ASSESSMENT REPORT

Section 75W Modification Catherine Hill Bay Residential Development MP10_0204 MOD 6

On 24 August 2017, the Proponent lodged a section 75W modification request (MP10_0204 MOD 6) seeking approval to modify the road layout in Stage 7.

Figure 1: Indicative Stage 7 Stormwater Layout

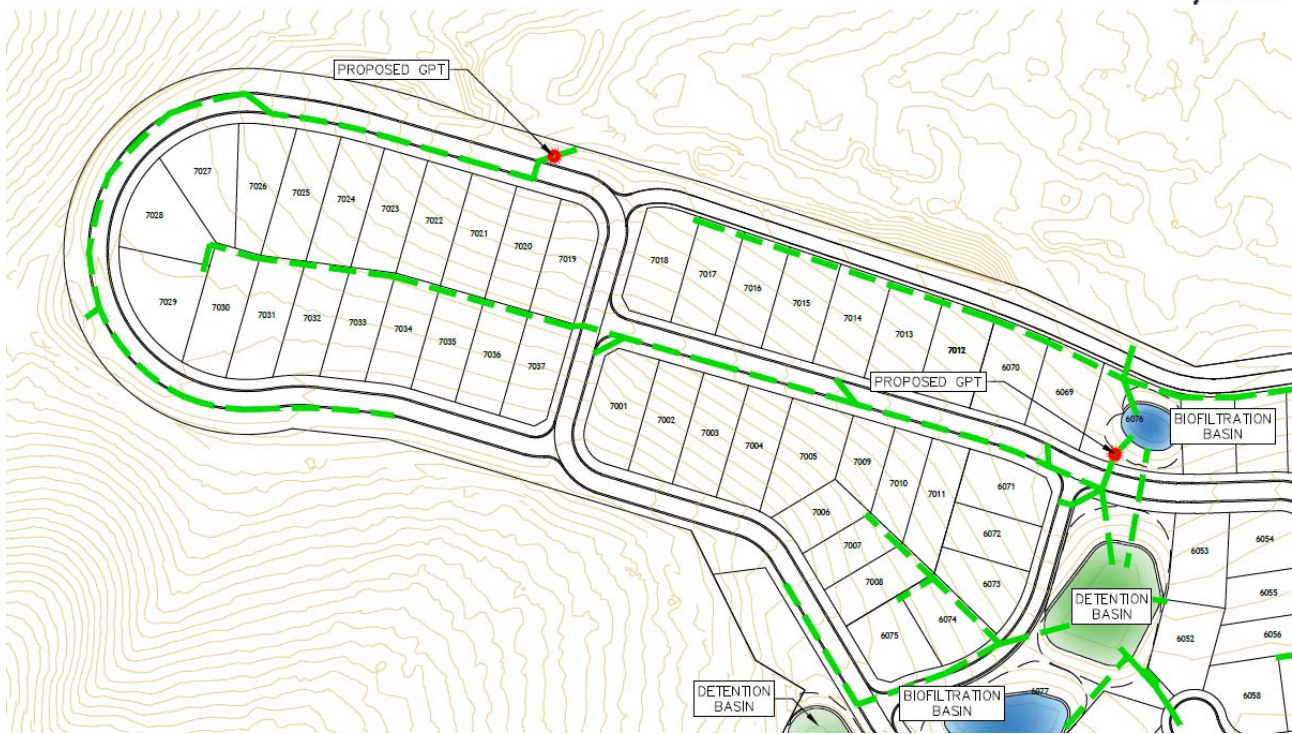
- all retaining walls be located outside the public road reserve and made of decorative masonry.
- appropriate provision of stormwater treatment in Stage 7, noting stormwater is proposed to be discharged directly to the adjoining National Park without treatment or provision of easements on National Park lands.

OEH raised concerns about stormwater discharging to its land leading to a small lagoon. The proposal could result in additional sediment entering the lagoon with associated environmental impacts. OEH advised it supports additional stormwater detention and water quality controls.

| Issue | Consideration | Recommendation |
|-------------------------------------|---|---|
| <p><i>Stormwater Management</i></p> | <ul style="list-style-type: none"> ● Council raised concern with the stormwater design, noting stormwater would be discharged directly to the adjoining National Park without treatment or provision of easements on the adjoining land. ● The stormwater plans indicate the majority of stormwater would be directed east to Stage 6 where it would then be treated. Only part of the site, which cannot discharge to Stage 6 due to the site topography, would flow onto the adjoining National Parks land after first passing through a gross pollutant trap. The majority of this water would originate from NPWS land upslope of the site and would be redirected by the drainage system back on to NPWS land. ● The Department referred the modification to OEH (which incorporates NPWS) which advised it had concerns that discharge to its land could impact on sediment entering a nearby lagoon with associated environmental impacts. As such OEH advises it supports additional stormwater detention and water quality controls. ● The Department considers the proposed modification would not significantly alter the extent of stormwater runoff to the adjoining NPWS land compared to the approved layout, which also includes provision for stormwater runoff to the adjoining land in a similar arrangement. ● The Department also notes existing condition B8 of the approval requires the final design of the stormwater system to be submitted to Council for approval. It also requires the development of a Stormwater Management Strategy which outlines how stormwater is to be contained within the site prior to discharge and ensure any discharge from the site | <p>Condition B8 is recommended to be updated to specifically ensure stormwater management strategies are applied to the discharge from Stage 7.</p> |

| <i>Issue</i> | <i>Consideration</i> | <i>Recommendation</i> |
|------------------------------|---|--|
| | <p>meets OEH and Council treatment targets. Other conditions also require water quality testing and monitoring.</p> <ul style="list-style-type: none"> • The Department considers the existing conditions would provide adequate safeguards to ensure stormwater is appropriately treated before discharging from the site. However, to remove any ambiguity about the need to demonstrate appropriate detention and treatment before discharging onto the adjoining land, a minor change to Condition B8 is recommended, to specifically refer to the stormwater discharges in Stage 7. • On this basis, the Department is satisfied the proposed modification would not result in any additional stormwater impacts beyond those already assessed and approved. | |

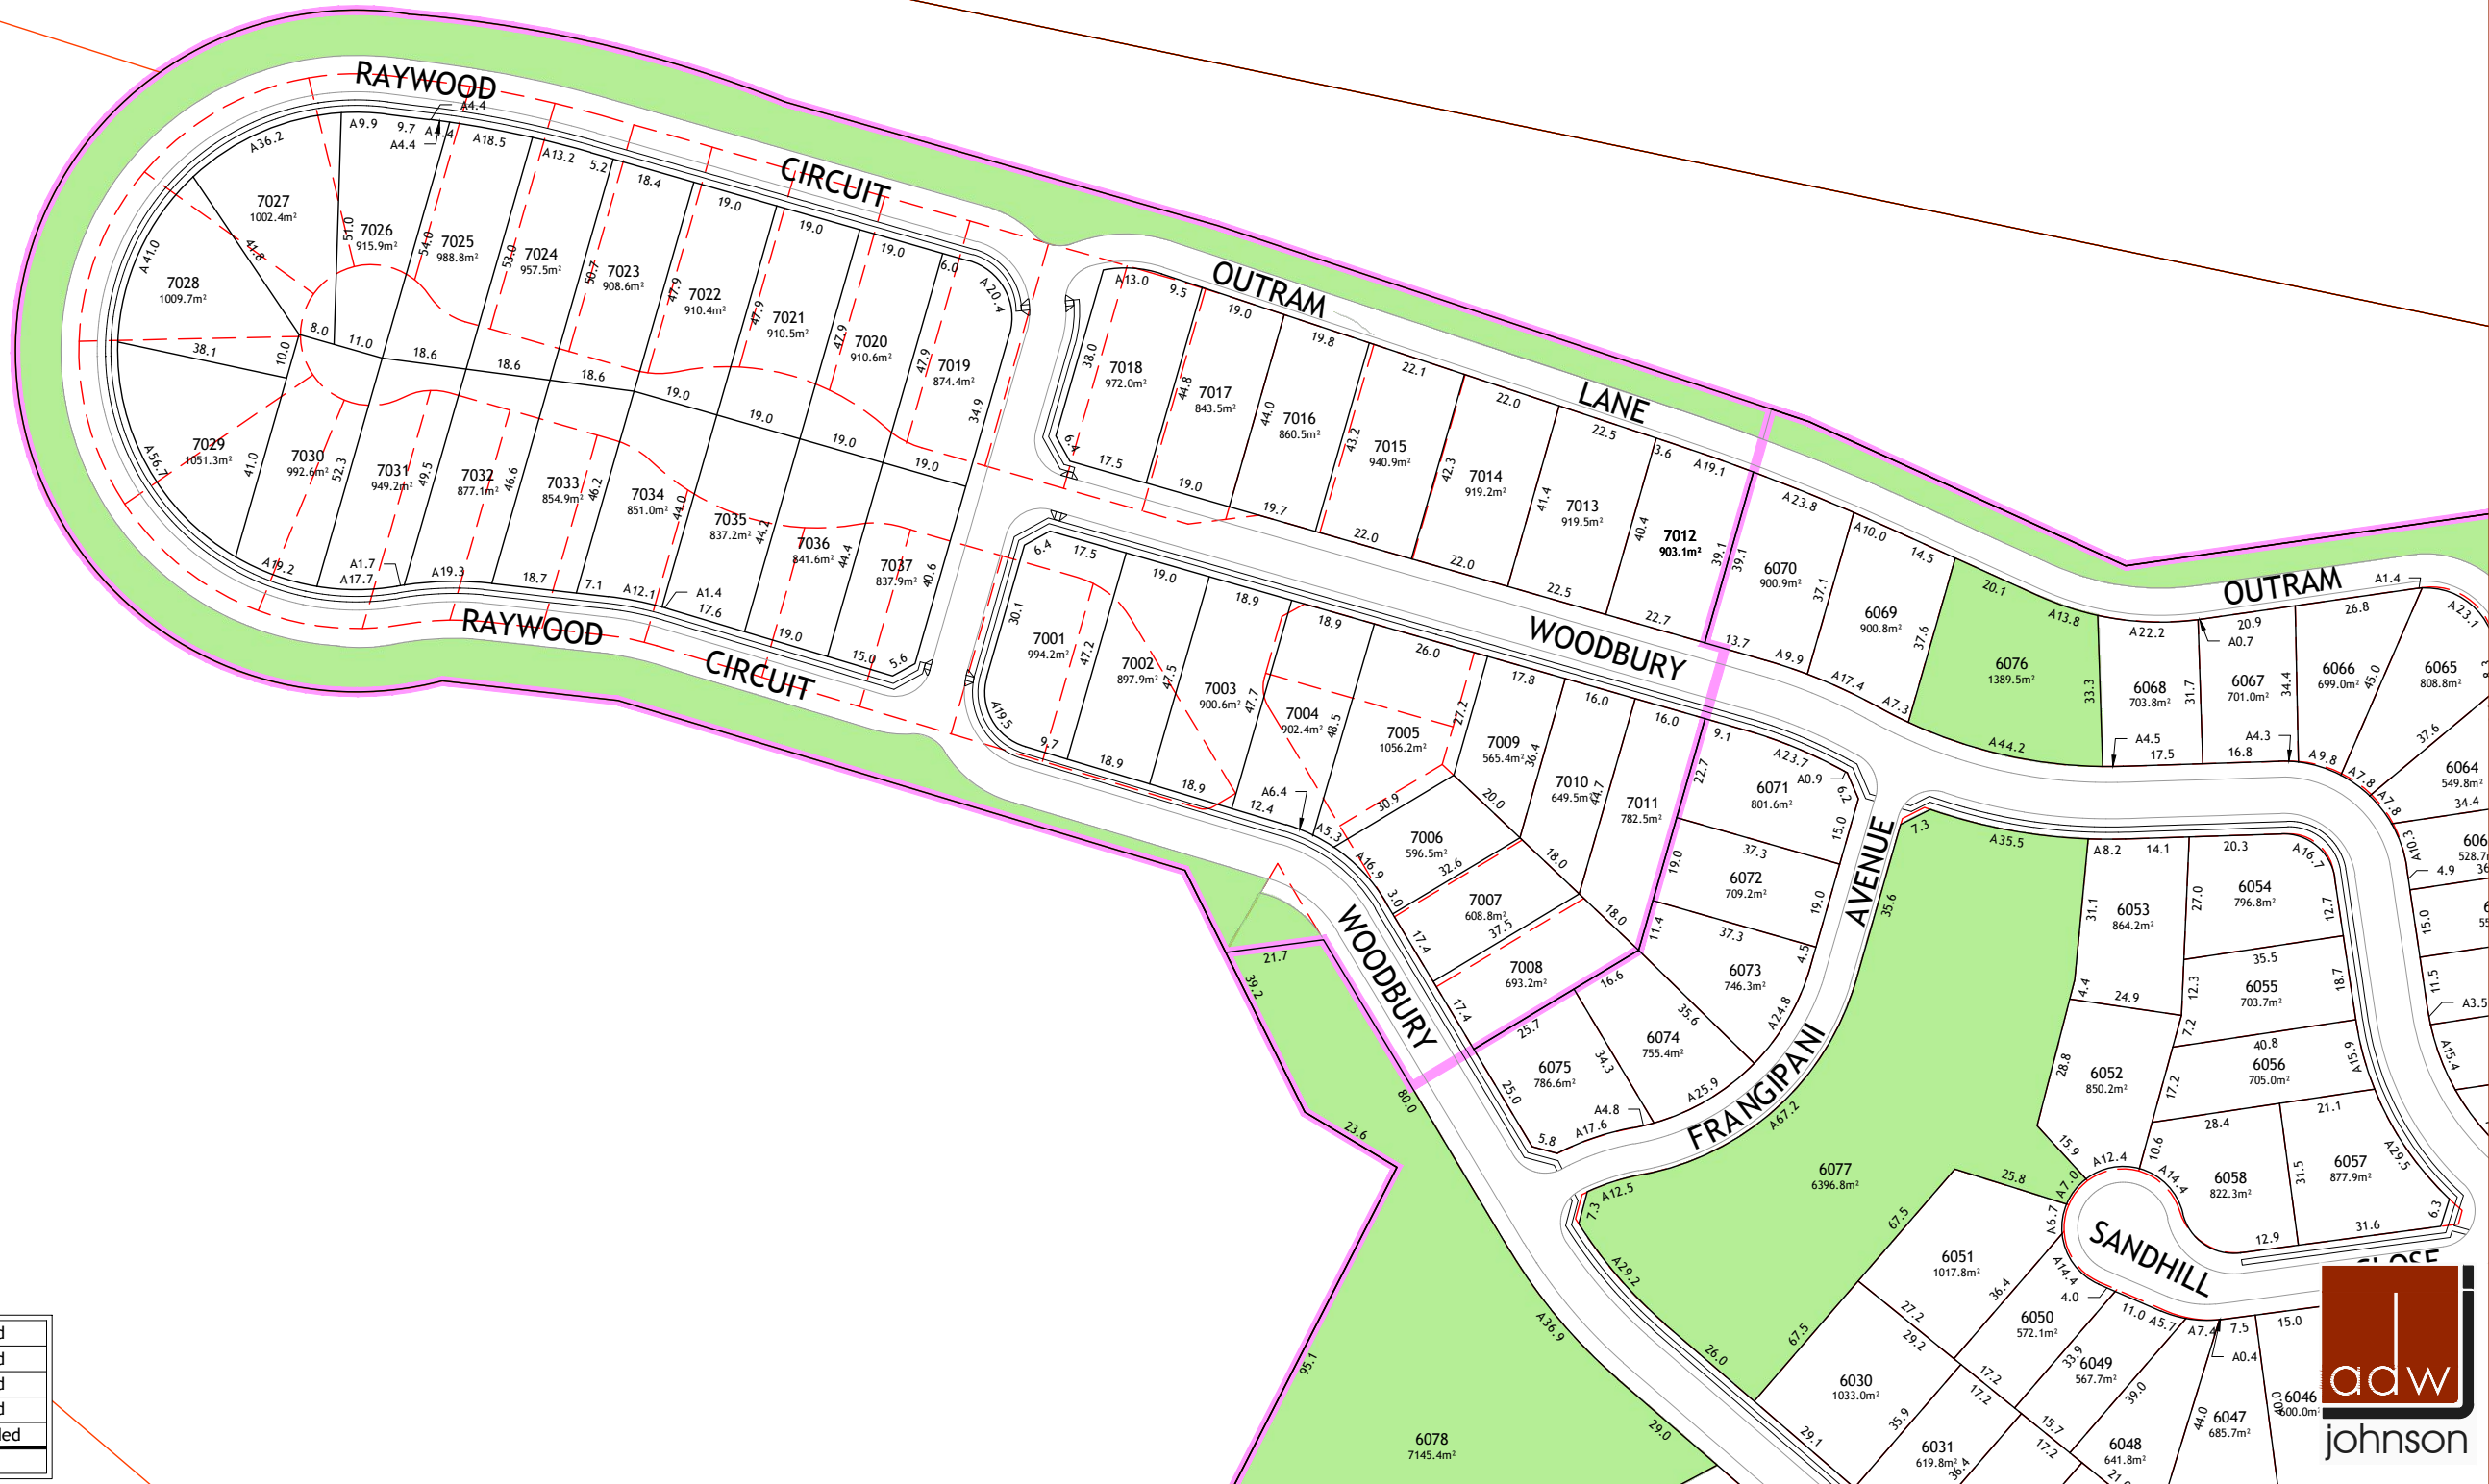
RFS raised concerns with the modified perimeter road, noting the road would have a length exceeding 500 metres from where it links with the internal road system, contrary to the requirements of Planning for Bush Fire Protection 2006. It also requested advice regarding the proposed front building alignments and expected bushfire attack levels for future dwellings.

| Issue | Consideration | Recommendation |
|---------------------------|--|---|
| <i>Bushfire Safety</i> | <ul style="list-style-type: none"> RFS initially raised concerns that the proposal would result in a perimeter road with a length exceeding 500 metres before joining the remainder of the internal road system, contrary to the requirements for road design in <i>Planning for Bushfire Protection 2006</i>. To address these concerns, the Proponent redesigned the | A condition is recommended requiring the proposed road to comply with Planning for Bushfire |

| Issue | Consideration | Recommendation |
|-------------------------------------|---|---|
| | <p>road layout so the perimeter road length would be 479 metres. The Proponent also provided a bushfire assessment which found that the revised layout maintains satisfactory egress arrangements in accordance with <i>Planning for Bushfire Protection 2006</i> as:</p> <ul style="list-style-type: none"> ○ it provides a widened two-way perimeter road around the development area, with hydrants at regular spacing ○ the road provides increased separation between the hazard interface and the residential lots. <ul style="list-style-type: none"> ● The bushfire assessment also advised that Asset Protection Zones (APZs) would be provided in accordance with the Bushfire Management Plan for the site previously endorsed by the RFS, and the proposal would not alter APZs, construction standards, emergency management, or landscaping requirements. ● RFS subsequently advised it raises no objection to the modification subject to a condition ensuring the road be designed in accordance with <i>Planning for Bushfire Protection 2006</i> and have a carriageway width of at least 8 metres. ● The Department is satisfied the revised subdivision and road layout can comply with the requirements of <i>Planning for Bushfire Protection 2006</i> and has included RFS's suggested conditions. The Department also notes existing conditions of approval require the establishment of APZs and the preparation of a Bushfire Risk Management Plan. Future development applications for new dwellings will also be required to be assessed against bushfire safety requirements. ● The Department is therefore satisfied the revised proposal would not result in any unacceptable bushfire risks, subject to the inclusion of RFS' recommended conditions. | <p>Protection and have a minimum carriageway width of 8 metres.</p> |
